Recommendation Report for Works to Tree(s) on trees subject to a Tree Preservation Order (TPO)

REF NO: FP/178/21/T

LOCATION: Junction of Wyke Lane North/Roundle Rd and Roundle Square,
o/s 1 & 2 Roundle Avenue and West side of Roundle Square
Felpham
PO22 8LB

PROPOSAL: Various works to various trees.

T6

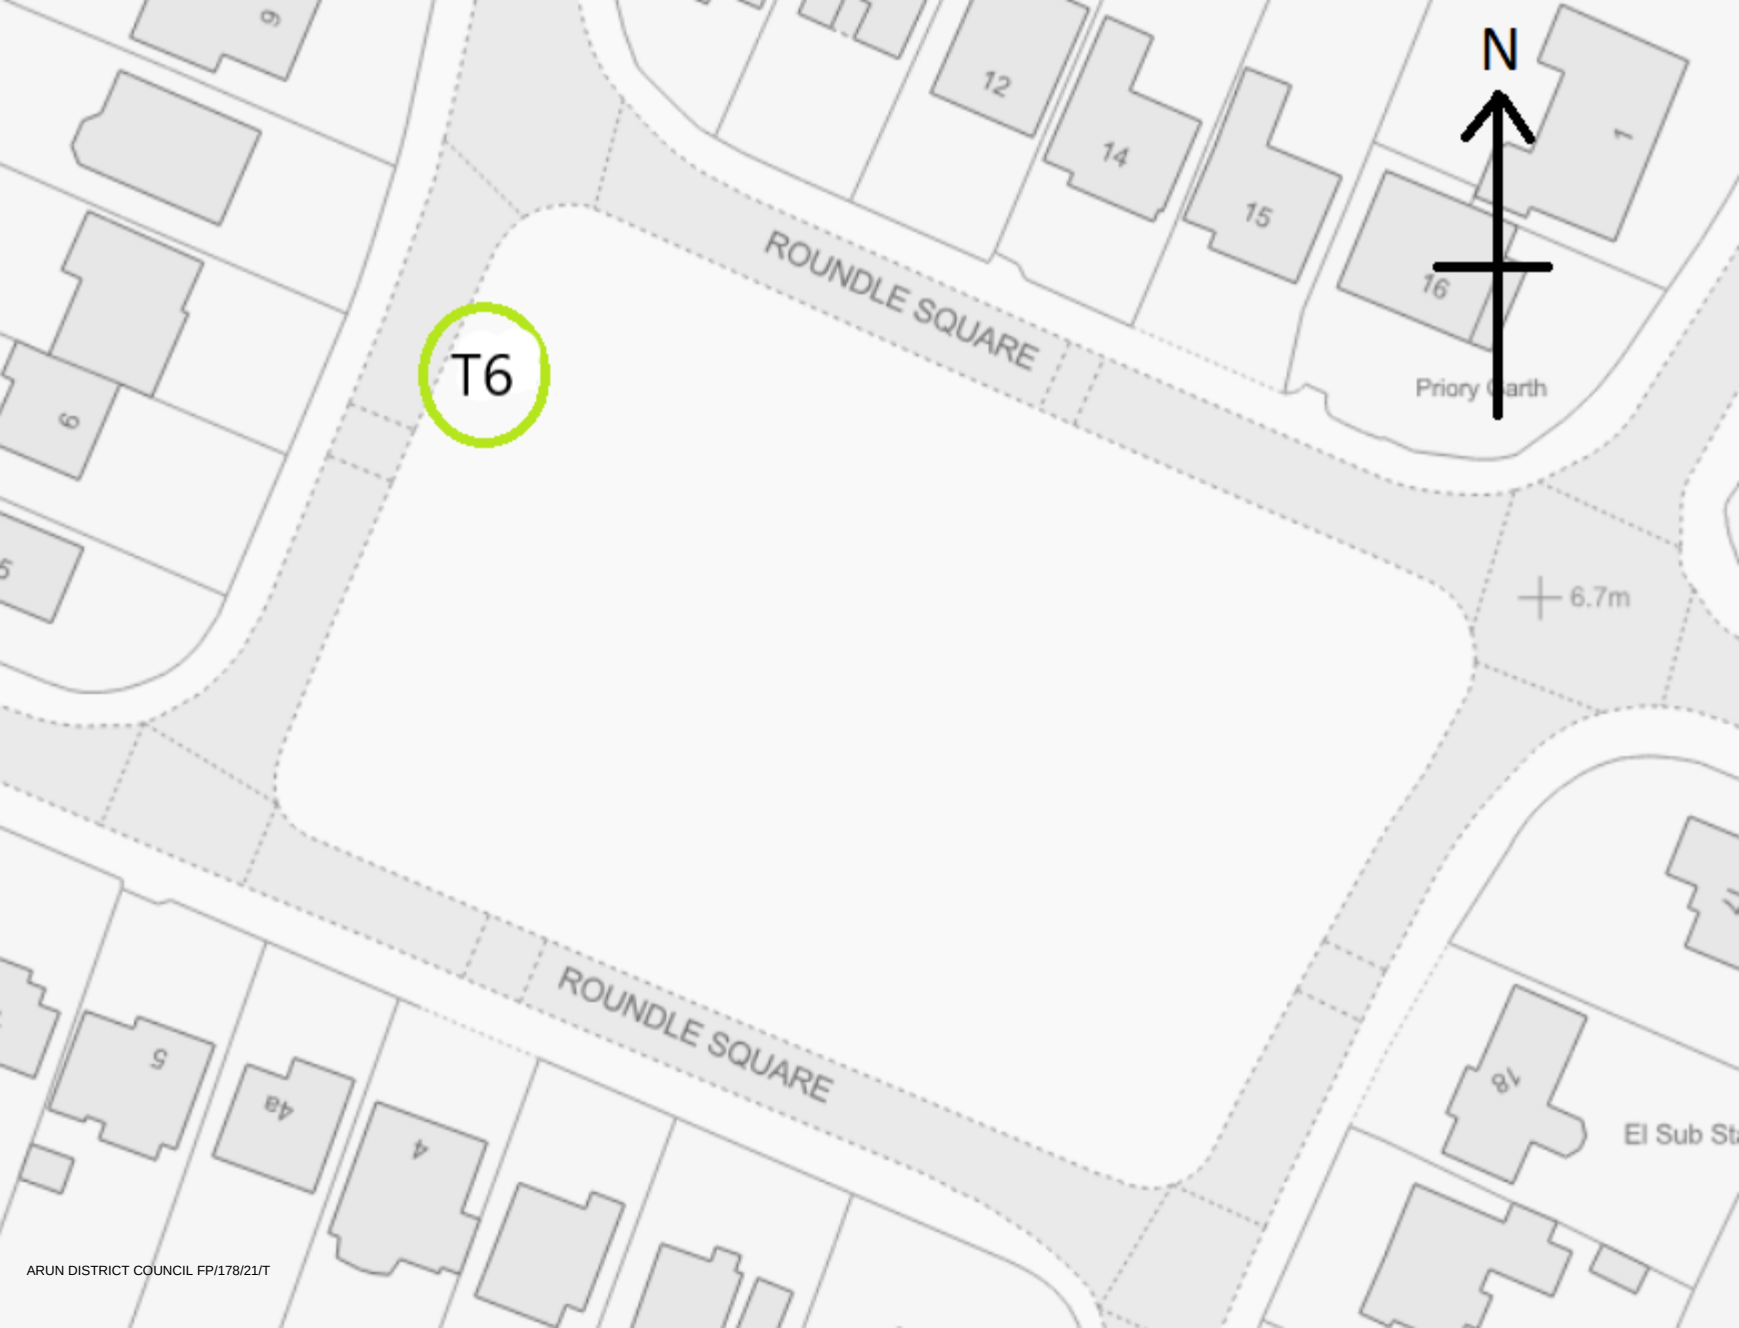
T6 is to sustain minor works to address a structural defect, which ought not to incur any loss of amenity.

T1

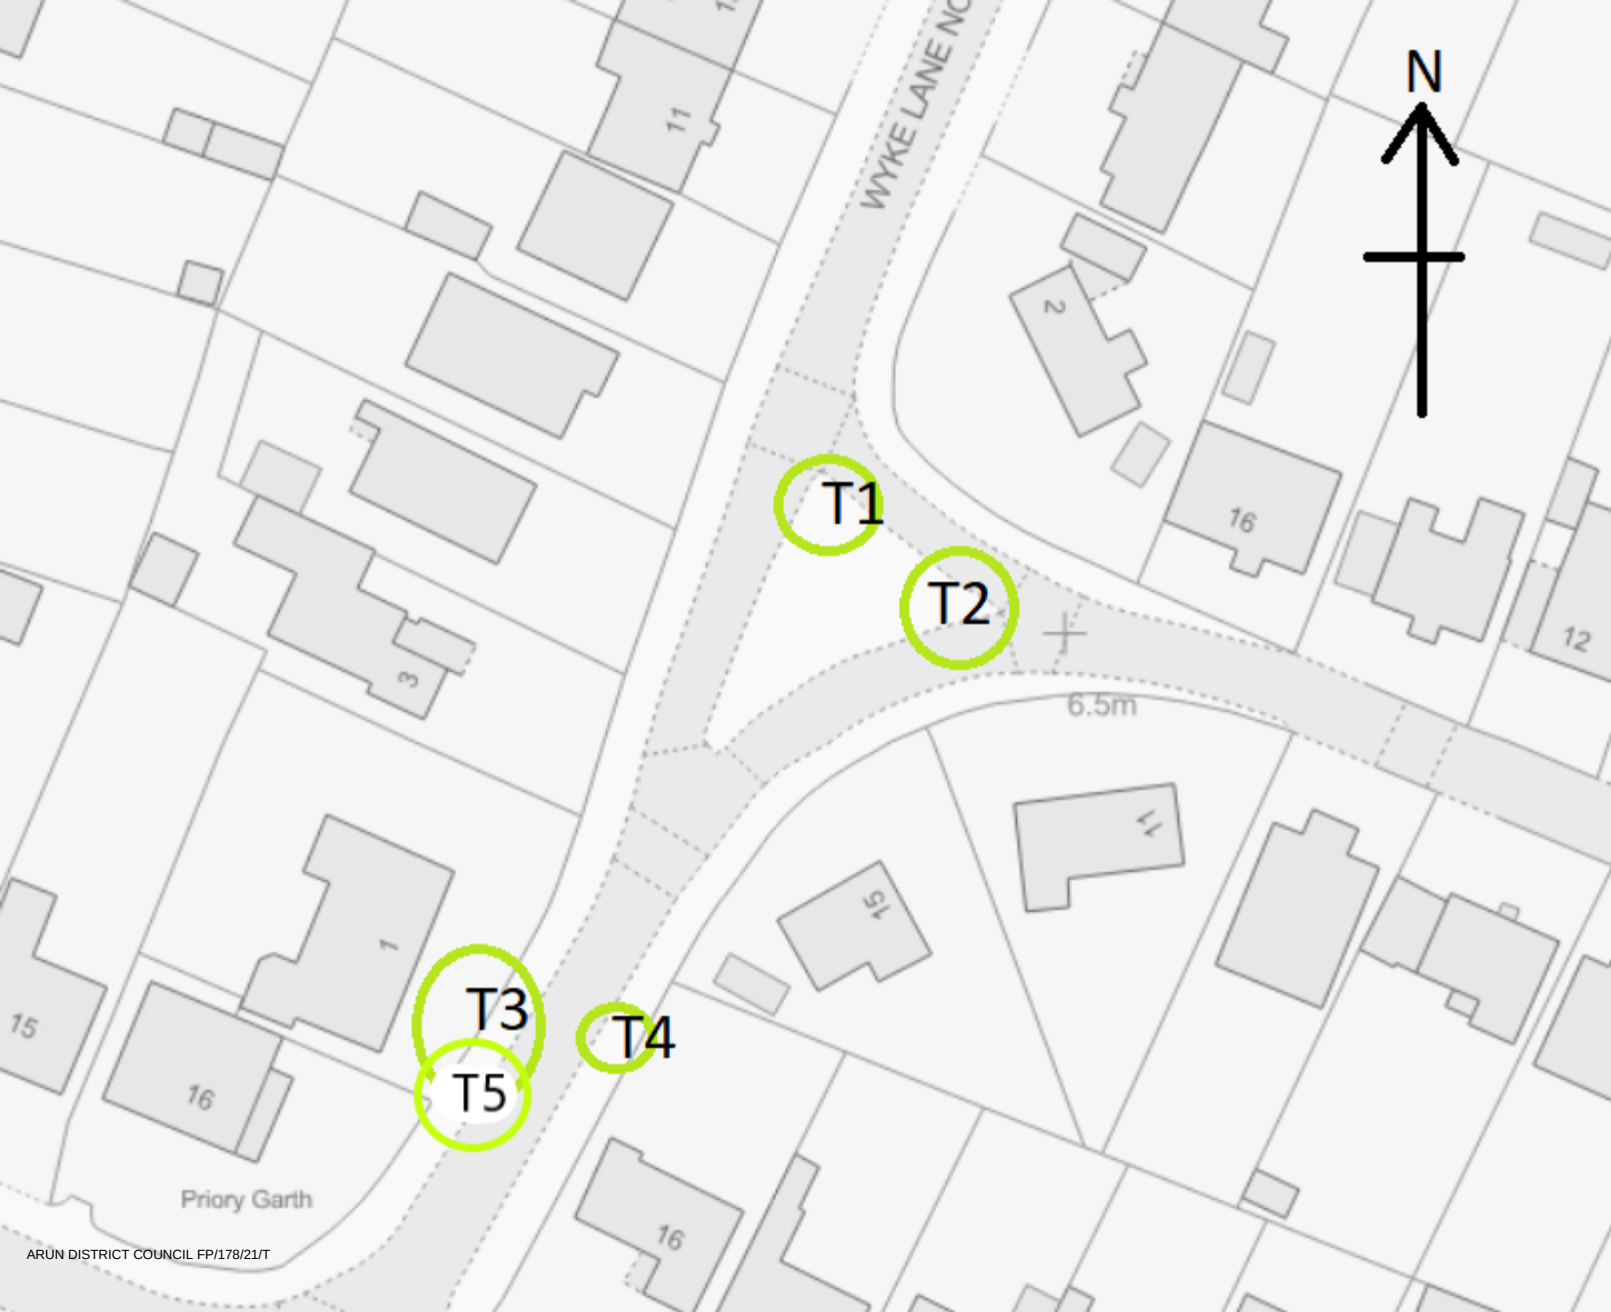
T1 and T2 have effectively been 'topped' in the past and this application seeks to repeat that operation. The extent of regrowth since last undertaken is such that it is now necessary to maintain a degree of structural integrity appropriate for their location.

The proposal to reduce overall height and spread (T1, T2) with a view to restricting their growth is justified and consistent with previous works approved by the Local Planning Authority. While a temporary loss of aesthetic value is inevitable, satisfactory canopy renewal and recovery should occur if the work is undertaken to a high standard and at an appropriate time of year.

The long-term vitality of trees (T1, T2) is best respected when significant pruning work such as proposed, is undertaken during the mid-winter (late-December to early-February) period. The work should only be undertaken during this period.

Part a) Where whole branches are to be removed and final cuts made close to the trunk or branch union they are to be made as shown in Figure 2 of BS3998:2010

Part b) Where branches are to be shortened back the final cuts are to be made at the correct angle shown in BS3998:2010 and adjacent to a live bud or lateral.

Part c) The removal of crown material which has developed since the last operation must be done sympathetically and with respect to established 'knuckles' so as not to extend beyond the point of origin.
